CITY OF ALBUQUERQUE

July 5, 2023

Re: Craft Hair Salon
115 Edith Blvd. SE
Traffic Circulation Layout
Engineer's/Architect's Stamp 8/8/2022 (K14D084A)

Based upon the information provided in your submittal received 6/12/2023, the above referenced plan cannot be approved for Building Permit until the following comments are addressed:

(A1) SITE PLAN

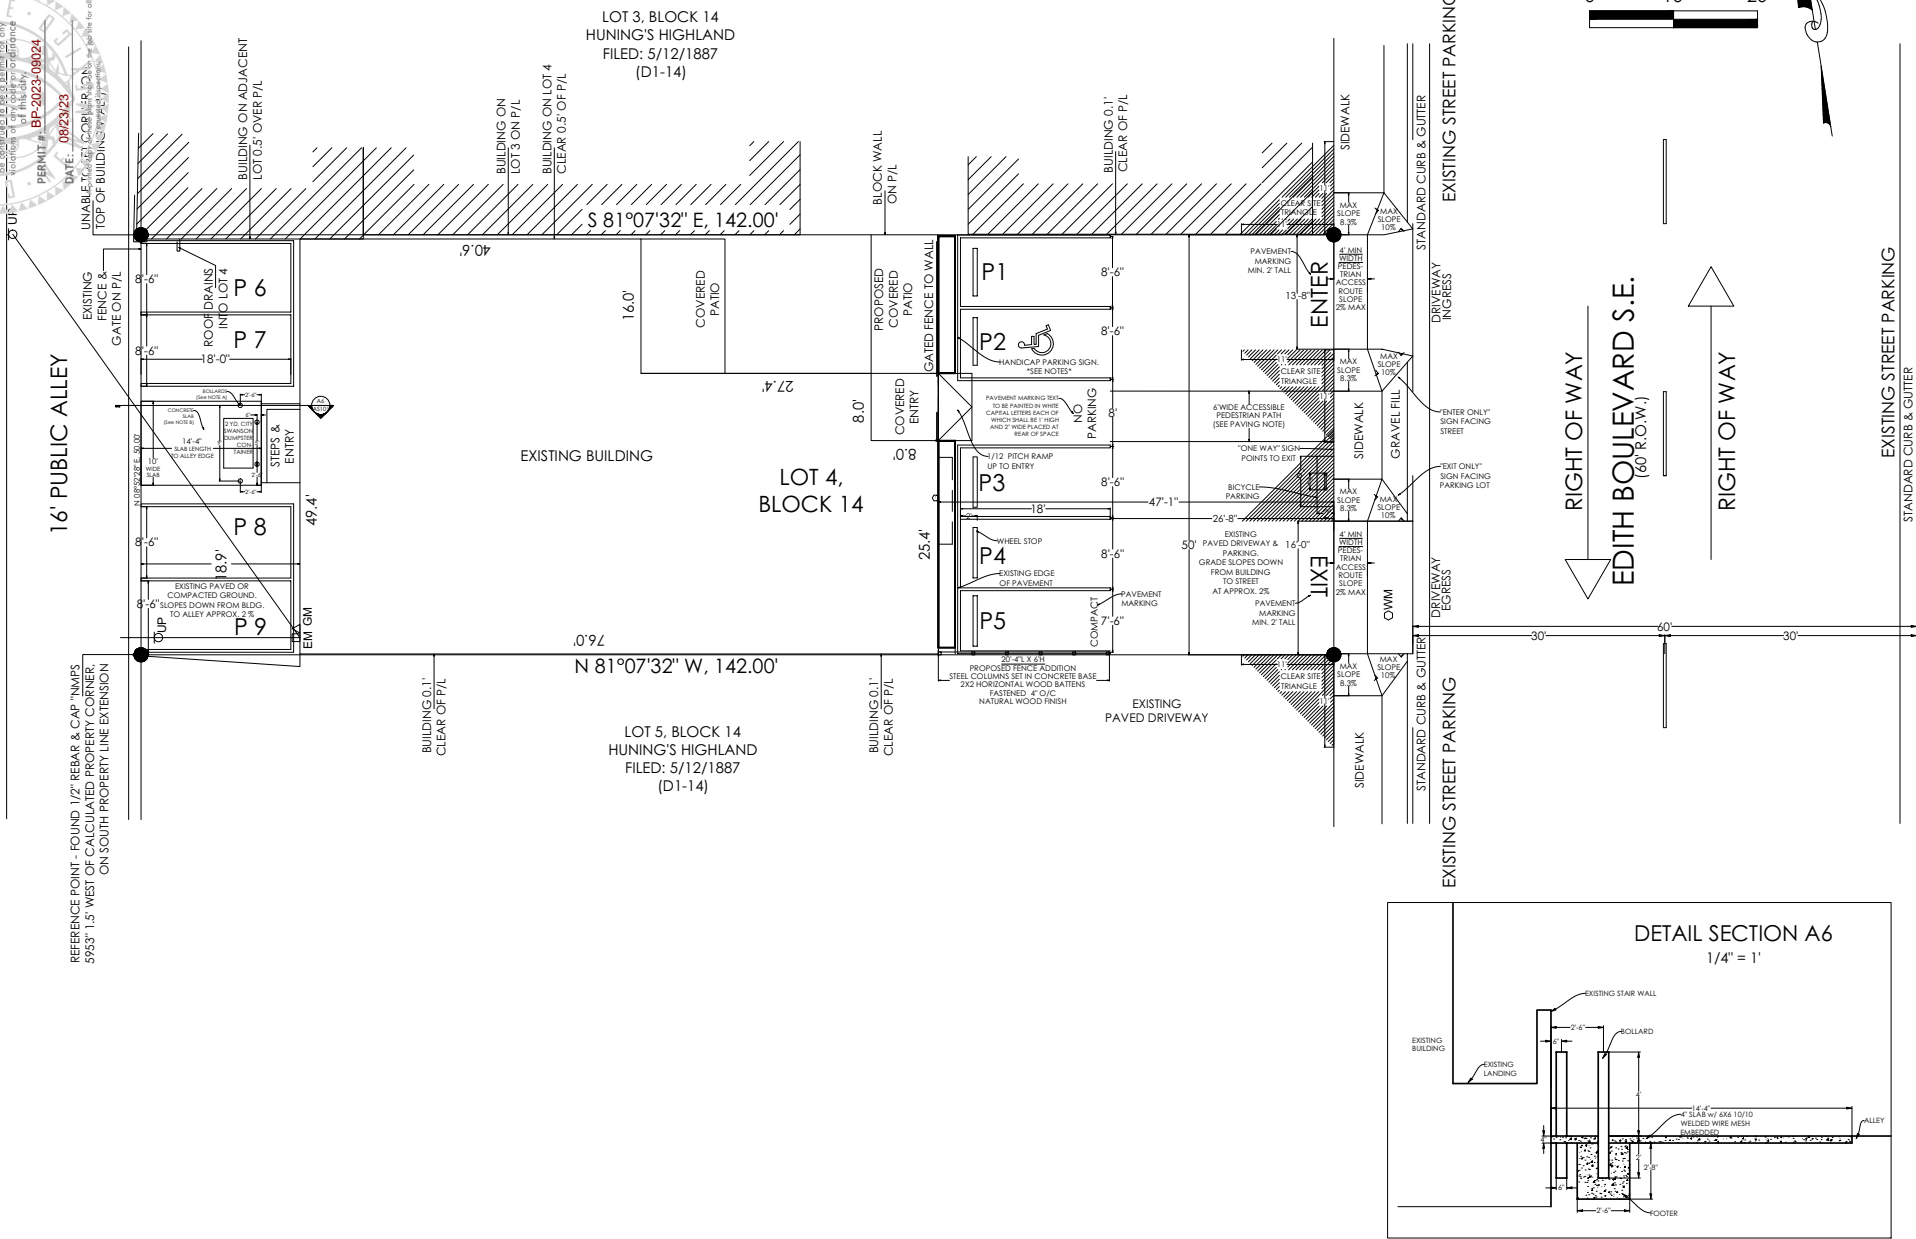
1. List the number of parking spaces required by the IDO as well as the proposed number of parking spaces including bicycle and motorcycle parking. You have shown numbers from the IBC requirements but you need to show what is required by the IDO (Table 5-5-1 Personal and business services, small 4 spaces/ 1,000 sq. ft. GFA).
2. Based on the access widths provided and the table below, these access points would be required to be one-way only. Please add pavement markings and signage to indicate enter and exit drives on the plan.

3. All accessways to the site from the adjacent roadway shall be ADA-compliant. Please see City standard drawings for driveways (2425A and 2425B).
4. The parking stalls in the front of the building are too small. The minimum parking stall dimensions are:

5. The ADA access aisle is too narrow. Van accessible aisles should be 8ft wide; all others should be 5ft wide, as there is only one ADA space it should be designated as van accessible. Your ADA space has extra width that can be used to expand the regular parking spaces and the access aisle to required width. ADA spaces use blue paint.

6. The ADA accessible parking sign must have the required language per 66-7-352.4C NMSA 1978 **"Violators Are Subject to a Fine and/or Towing."** Please call out detail and location of signs.

7. The ADA access aisles shall have the words **"NO PARKING"** in white capital letters, each of which shall be at least one foot high and at least two inches wide, placed at the rear of the parking space so as to be close to where an adjacent vehicle's rear tire would be placed. (66-1-4.1.B NMSA 1978)

8. You mentioned bike racks in your drawing but you need to show them. Please make sure they meet the following design guidelines:
 - a. The rack shall be a minimum 30 inches tall and 18 inches wide.

9. Bicycle racks shall be sturdy and anchored to a concrete pad.
10. A 1-foot clear zone around the bicycle parking stall shall be provided.
11. Bicycle parking spaces shall be at least 6 feet long and 2 feet wide.

12. Per the DPM, a 6 ft. wide ADA accessible pedestrian pathway is required from the public sidewalk to the building entrances. Please clearly show this pathway and provide details.

13. Please provide Solid Waste approval.
14. Please provide a sight distance exhibit
15. Show the clear sight triangle and add the following note to the plan: "Landscaping and signage will not interfere with clear sight requirements. Therefore, signs, walls, trees, and shrubbery between 3 and 8 feet tall (as measured from the gutter pan) will not be acceptable in the clear sight triangle.

16. Add a note stating "All broken or cracked sidewalk must be replaced with sidewalk and curb & gutter." A build note must be provided referring to the appropriate City Standard drawing.
